REPORT UPDATE

Application No: EP/168/19/PL

Recommendation Report for Planning Permission

PROPOSAL: 1 no. dwelling & alterations to roof of existing dwelling (4 Beechlands Cottages) including the provision of new dormer to front elevation.

DRAWING TITLE
Proposed Plans and Elevations

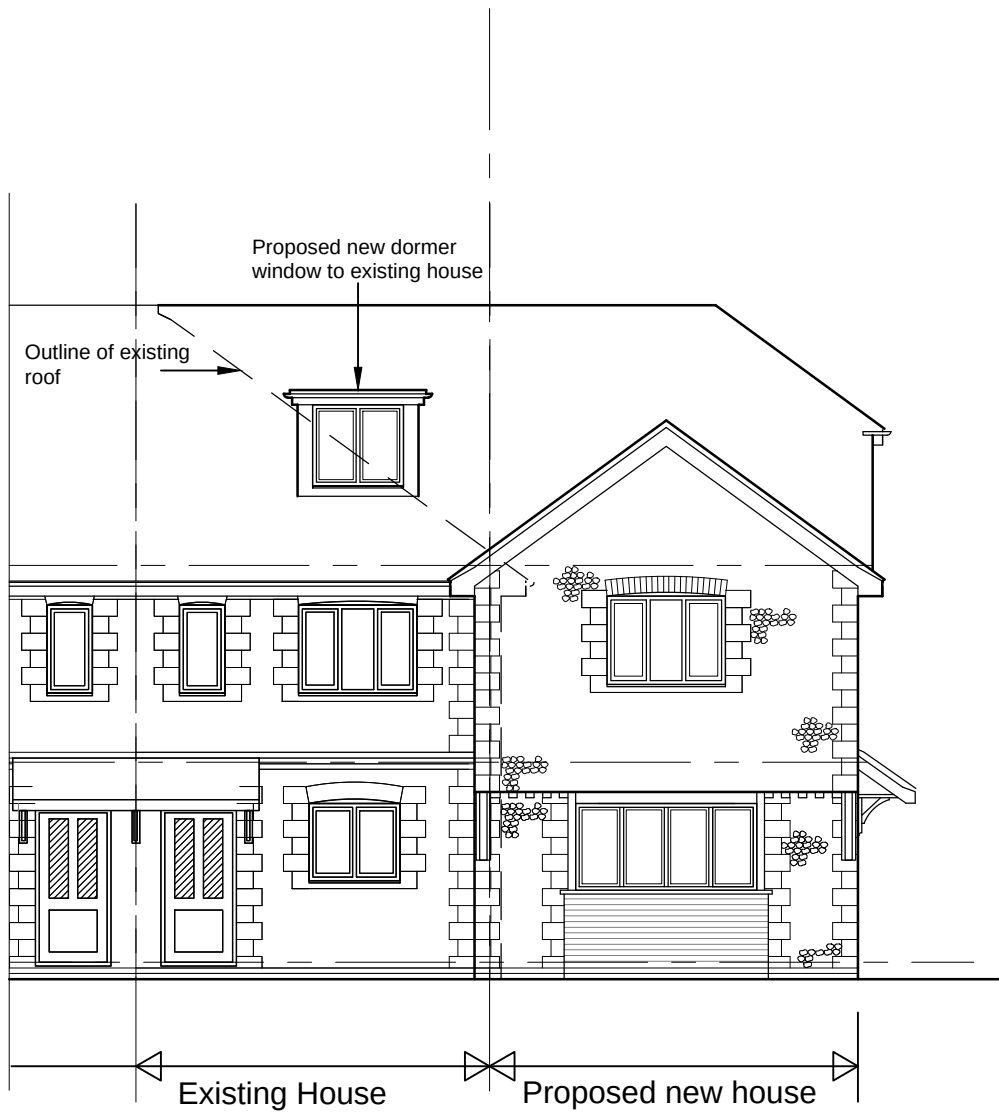
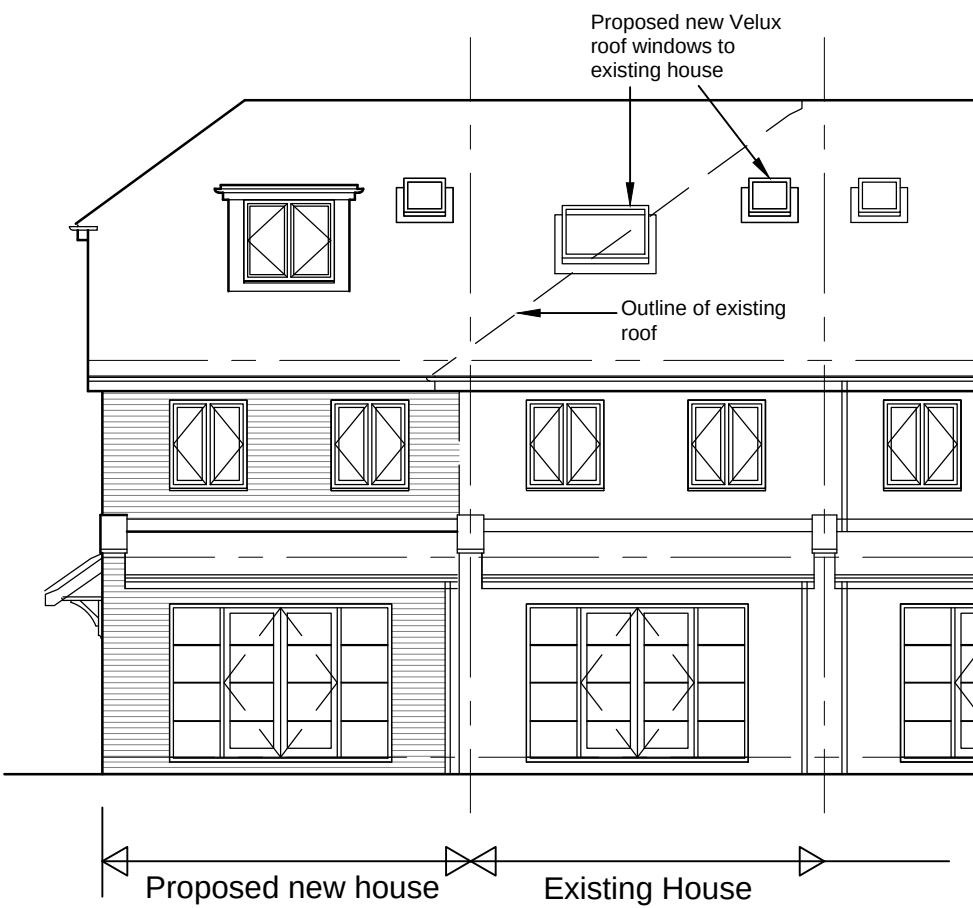
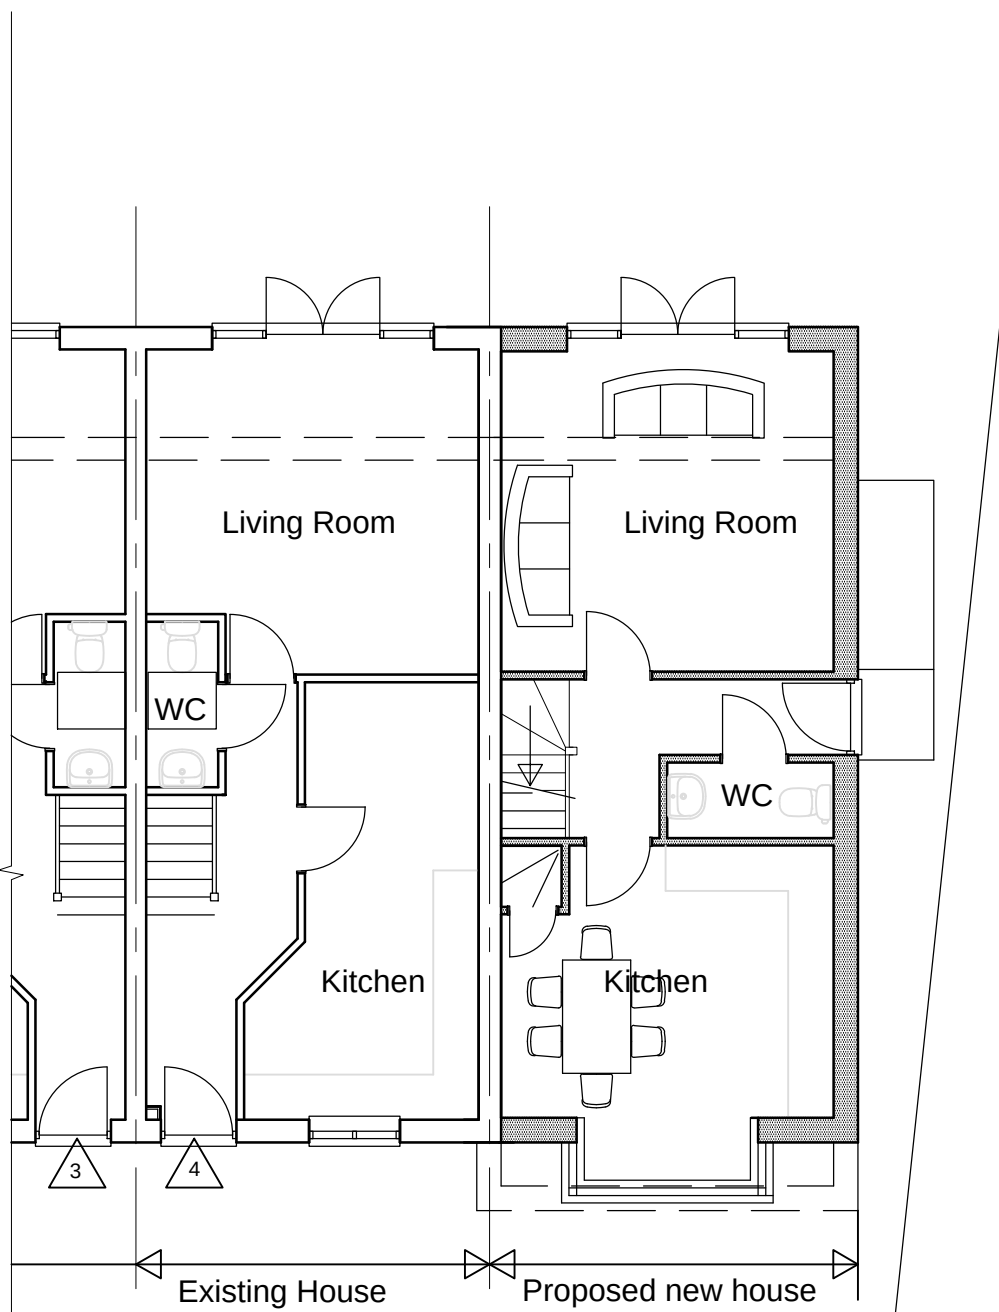
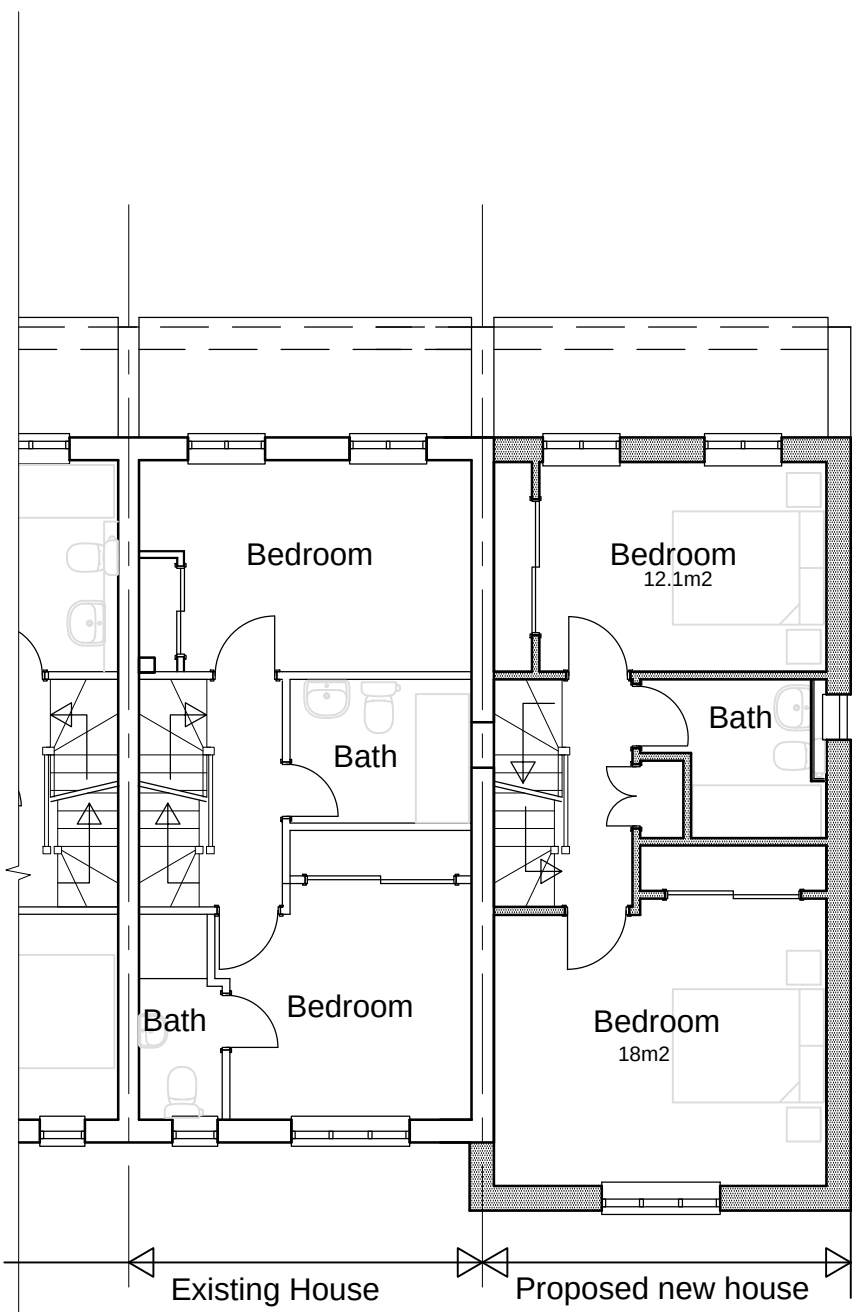
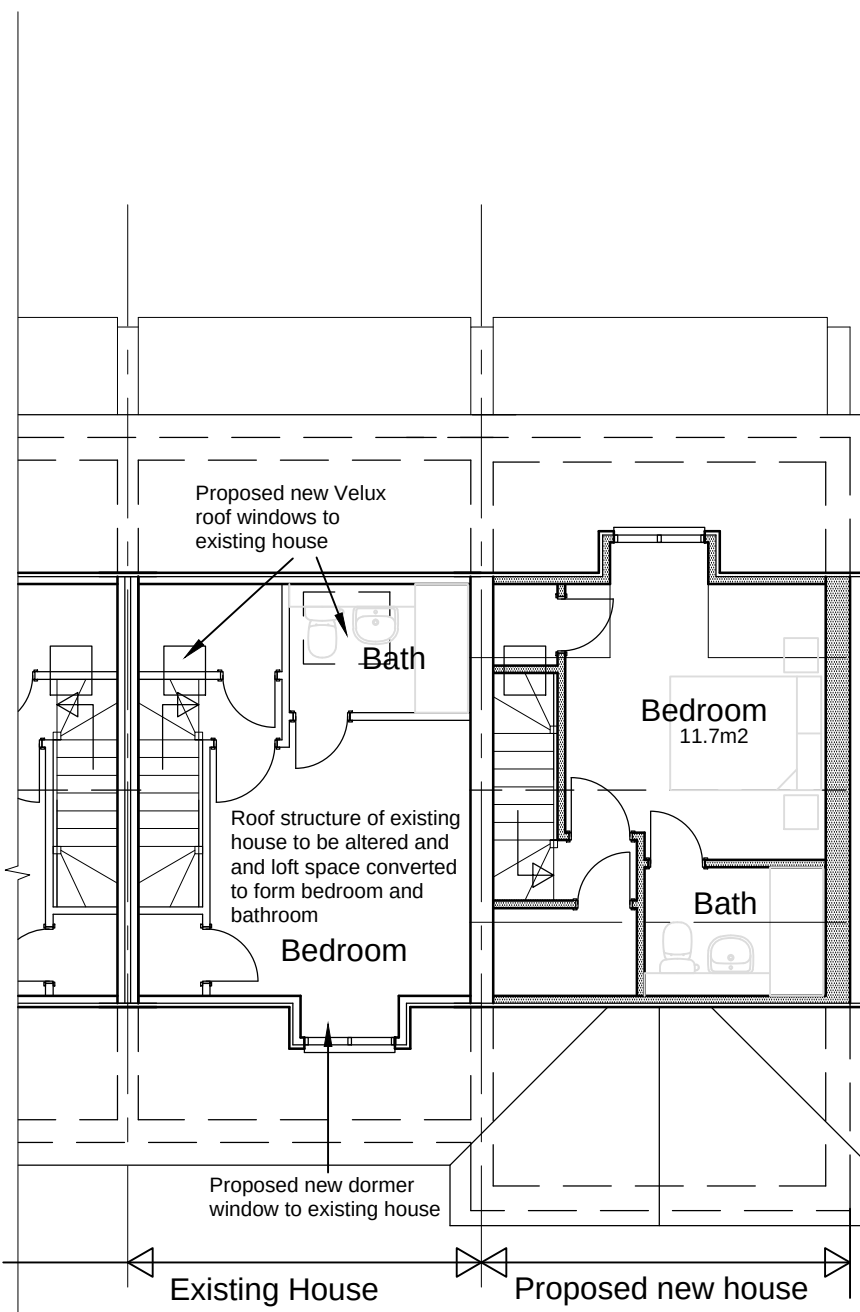
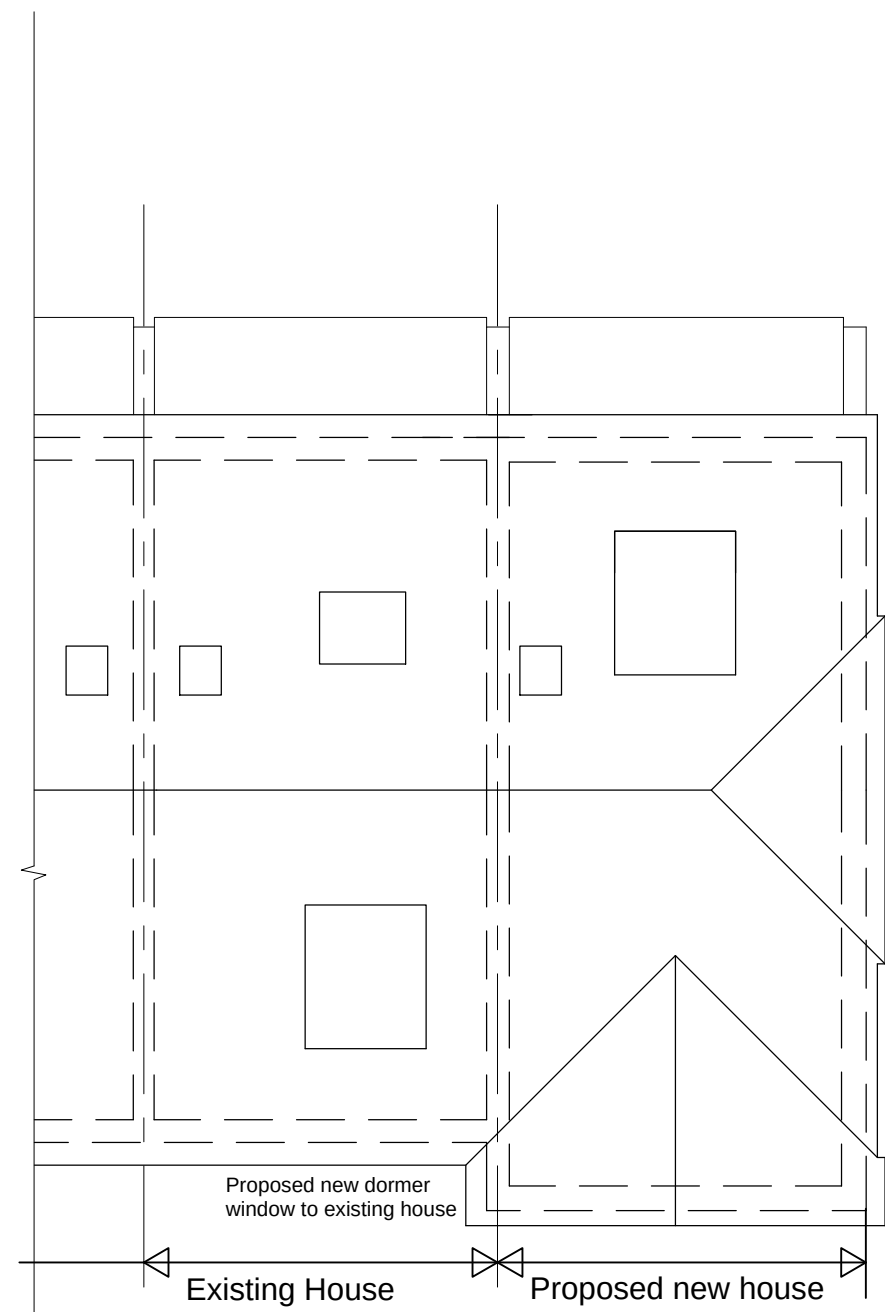
The proposal will alter the appearance of the existing terrace. At present both ends of the terrace are symmetrical with fully hipped roofs without front dormers. The proposal will end this symmetry by adding to the eastern end of the terrace a half hipped roof dwelling with a prominently sized front dormer window. This will not only end the existing uniform design of this terrace but also not replicate, as is the case at the moment, the design of the opposite side of terraced dwellings. The proposals will clearly not result in a form of development that fully respects the character of the existing terrace. However, such a

The proposed roof extension and new dwelling would be located approximately in line with the existing terraces rear and front building lines (except the 90 cm projection of the front element of the new dwellinghouse). The development would therefore not negatively impact the existing terraced dwellings in terms of a loss of light, overbearing impact or loss of privacy.

There are no dwellings within 23 metres of the front or rear elevations of the proposed dwelling or new roof dormer extension and the bungalow to the east side beyond the side access road has no primary habitable facing windows in its side elevation 13 metres away from the new side elevation of the dwelling proposed. A first floor bathroom window in the side elevation of the proposed dwelling at first floor level would be conditioned to be obscure glazed and non opening below 1.7 metres in height to protect the privacy of the neighbouring bungalow at 1 Beechlands Close.

Reason: For the avoidance of doubt and in the interests of amenity and the environment in accordance with policy D DM1 of the Arun Local Plan.
- 3 The materials and finishes of the external walls, rainwater goods, windows and roof of the new dwellinghouse and roof extension hereby permitted shall match in colour and texture those of the existing terrace of dwellinghouses at both the front and rear.

- 6 The window at first floor level in the east facing side elevation of the proposed new end terraced dwelling shall, at all times, be obscure glazed and fixed shut up to 1.7 metres in height from ground floor level.

DRAWING TITLE			
Proposed Site Plan Block and Location Plans			
DATE	SCALE	DRAWN BY	GIM
Sept 2016		CHECKED BY	
JOB NO.	DRAWING NO.	REVISION	
1671	2.03	B

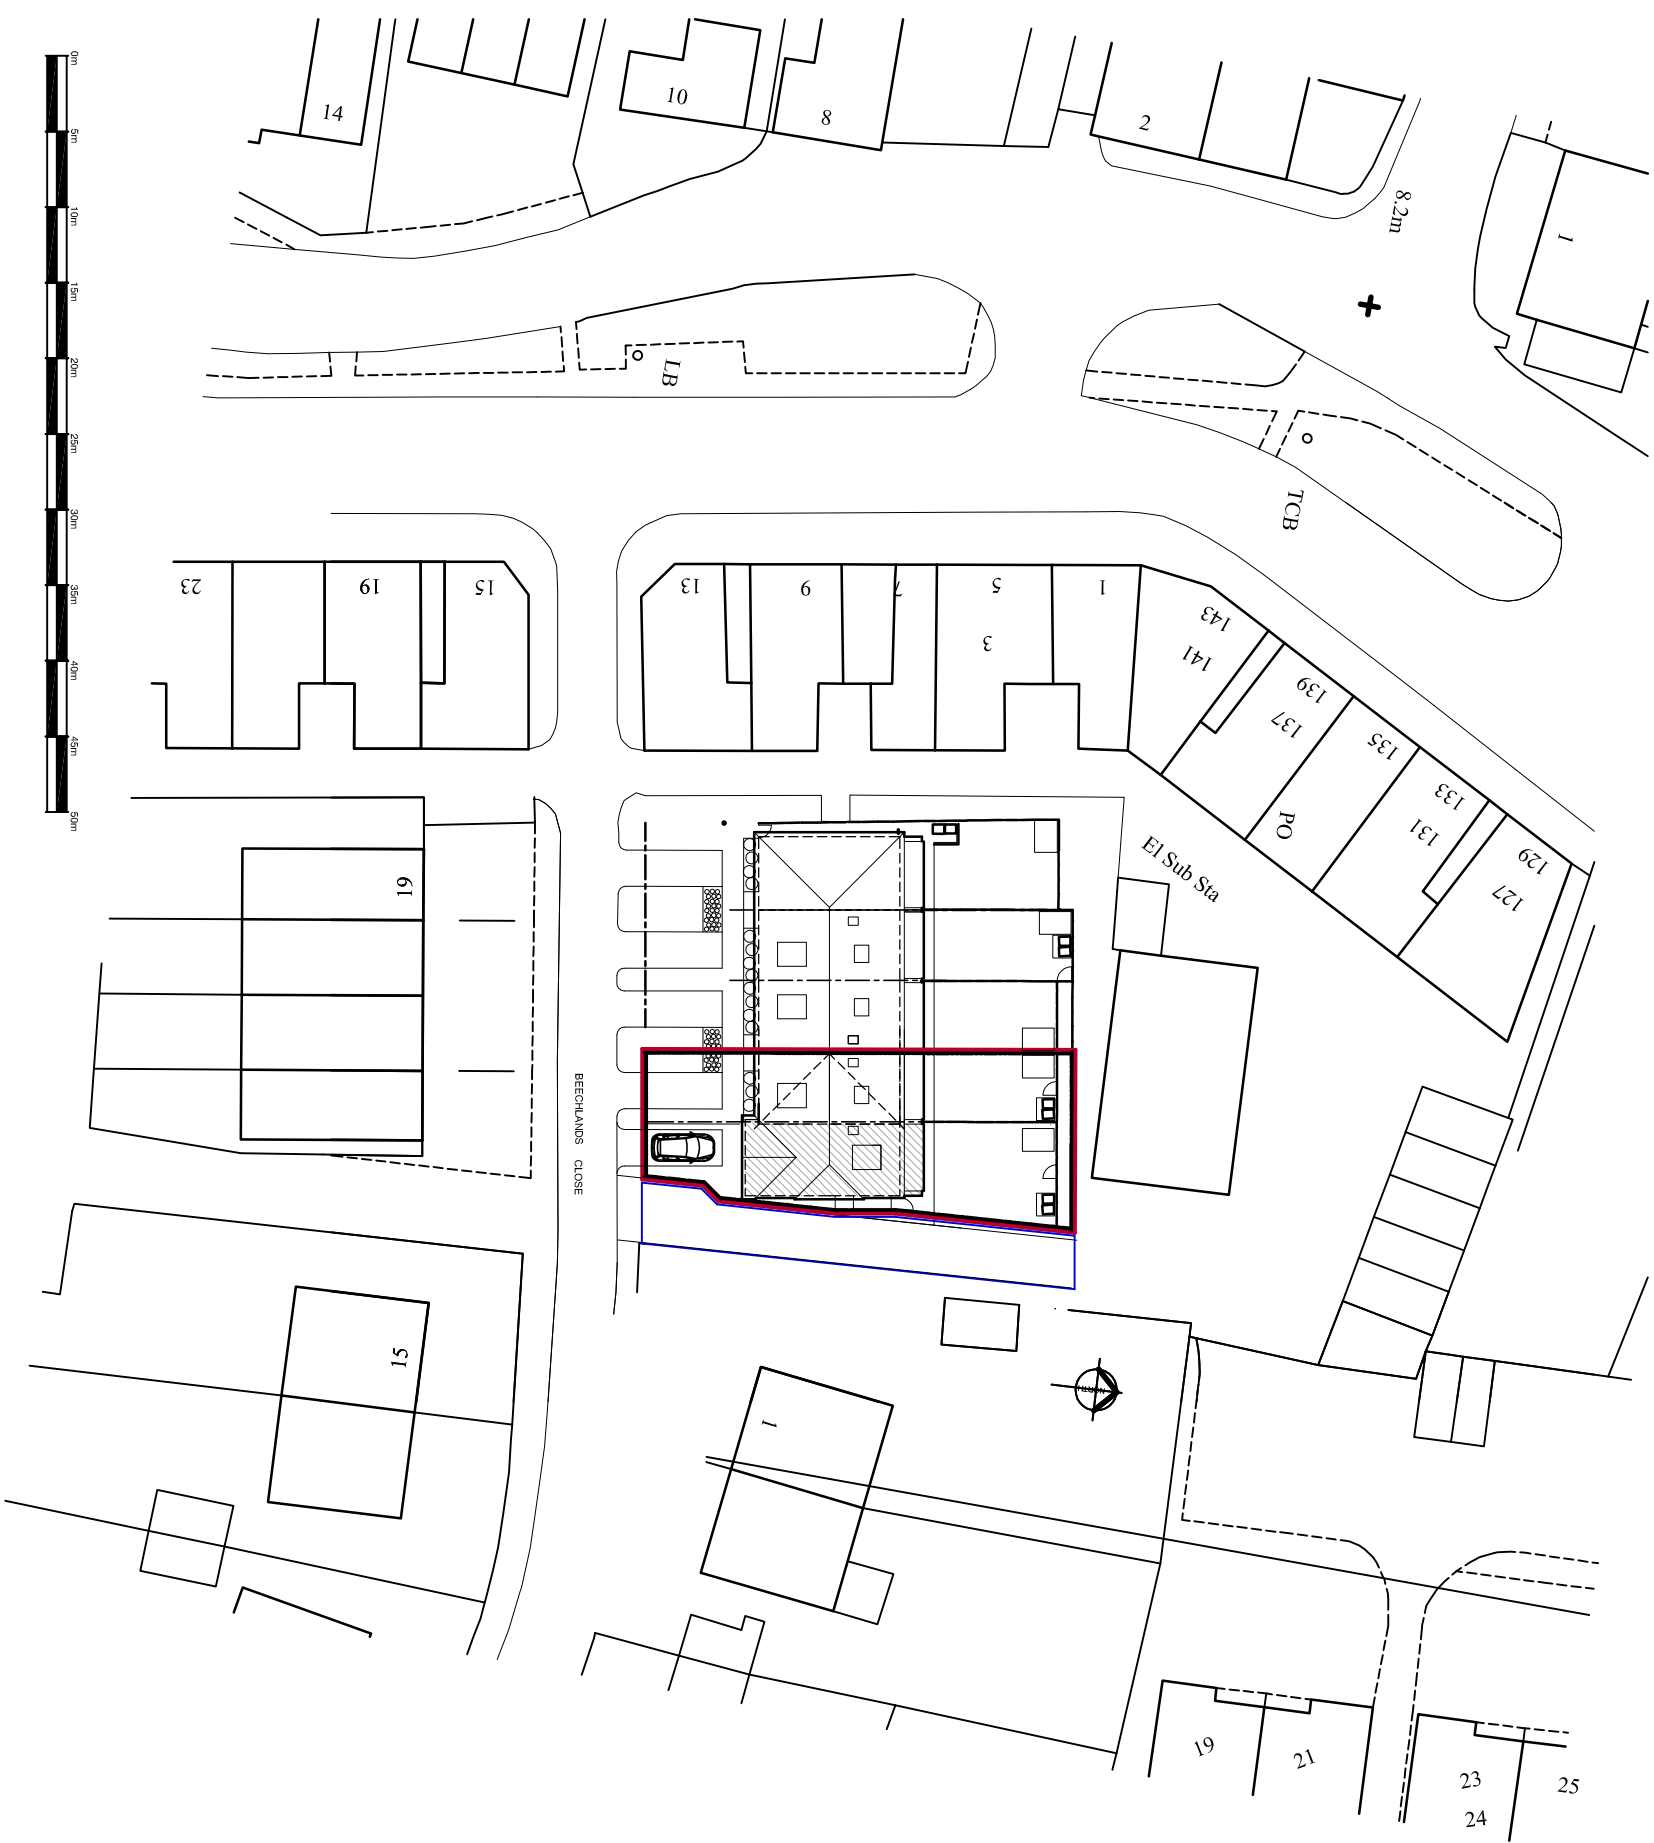
Width of road to the side of the development will not allow for 2 vehicles to pass one another.

The development would restrict access for cars and service vehicles to the rear of commercial premises and properties on North Lane.

In addition, WSCC Highways consider that use of the side access road to the east of the new dwelling would not be heavily used. According to County Highways the side access to the dwelling would be reduced in width to 3 metres in width at its narrowest point but would allow for single file vehicle access, which given the low level of traffic anticipated would be acceptable.

No objection to the proposal has been received from the Highways Authority, West Sussex County Council.

WSCC Highways Authority have made no objection to the proposed provision of 1 parking space for the proposed new dwelling and the location of the property is considered to be sustainable with good access to shops, facilities and public transport on nearby Sea Road.
